Recommendation Report for Planning Permission

REF NO: BR/320/18/PL

LOCATION: 9B Waterloo Square
Bognor Regis
PO21 1TE

PROPOSAL: Two storey side extension to form 2 No. self contained flats, replacement of ground floor front window with bay window, flat roof canopy to side elevation, porch extension to rear elevation, first floor balcony & insertion of flush fitting sun pipe. This application affects the character & appearance of The Steyne Conservation Area.

PROPOSED ELEVATIONS

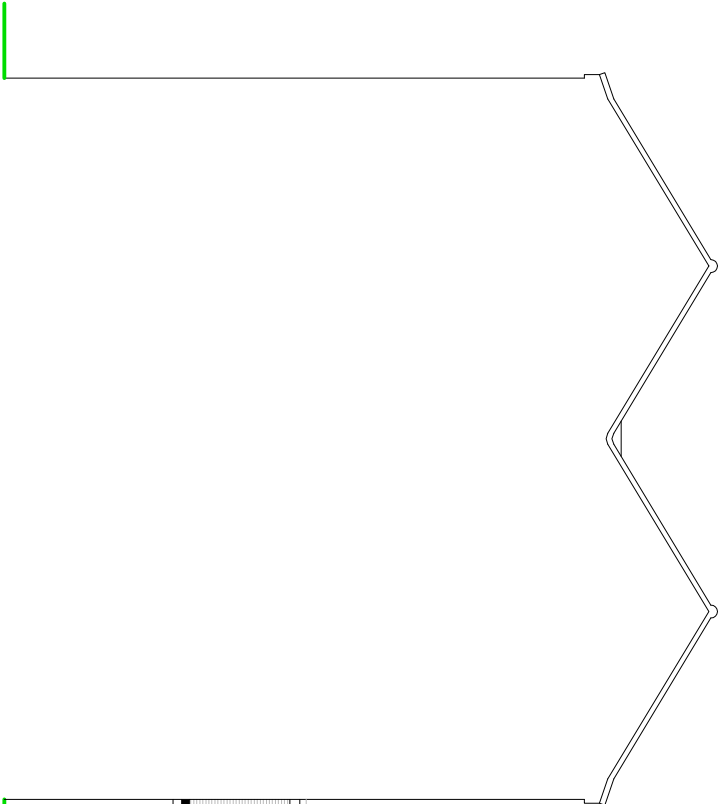
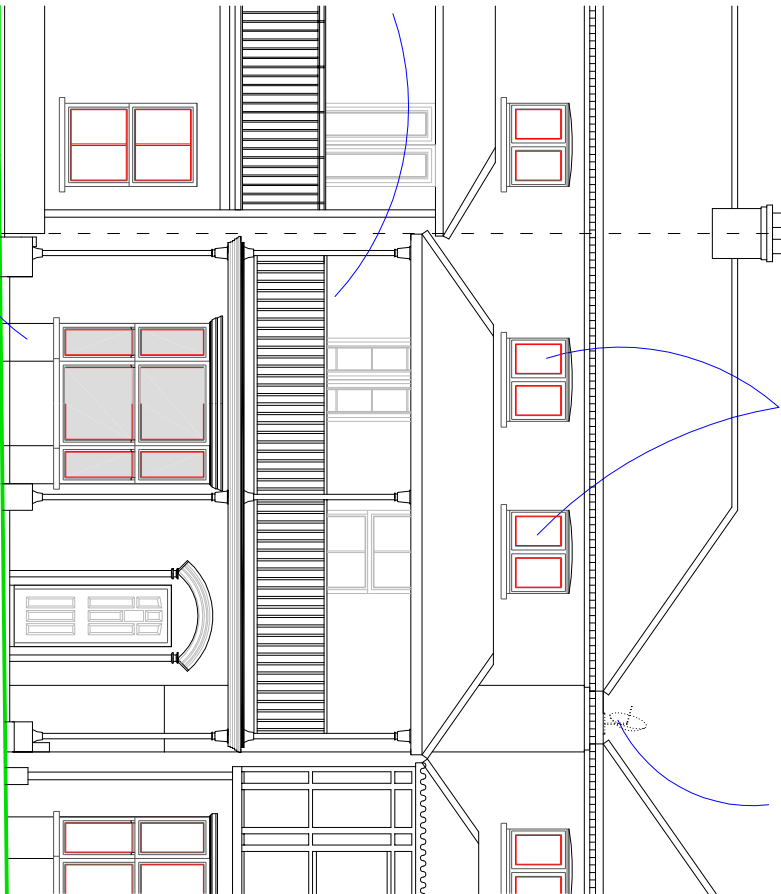
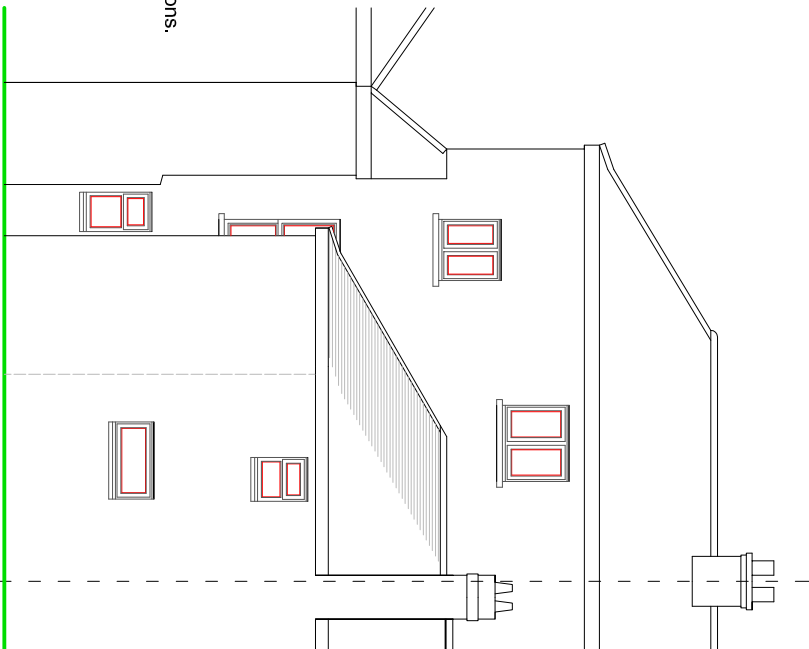
The reinstatement of the canted bay window and details to the projecting first floor balcony are positive as it will lead to the enhancement of the front elevation, and its significance.

No comment is made to the existing inappropriate windows elsewhere within the property. However, new windows should be of an appropriate material and appearance that reflect the status of the building as a listed structure. The windows should be the same colour as the existing ones.

- Details of the railings
- Details of the new windows

- 3 No new windows shall be inserted and railings fixed until details of new windows and railings have been submitted to and approved by the Local Planning Authority and implemented in accordance with the approved details.
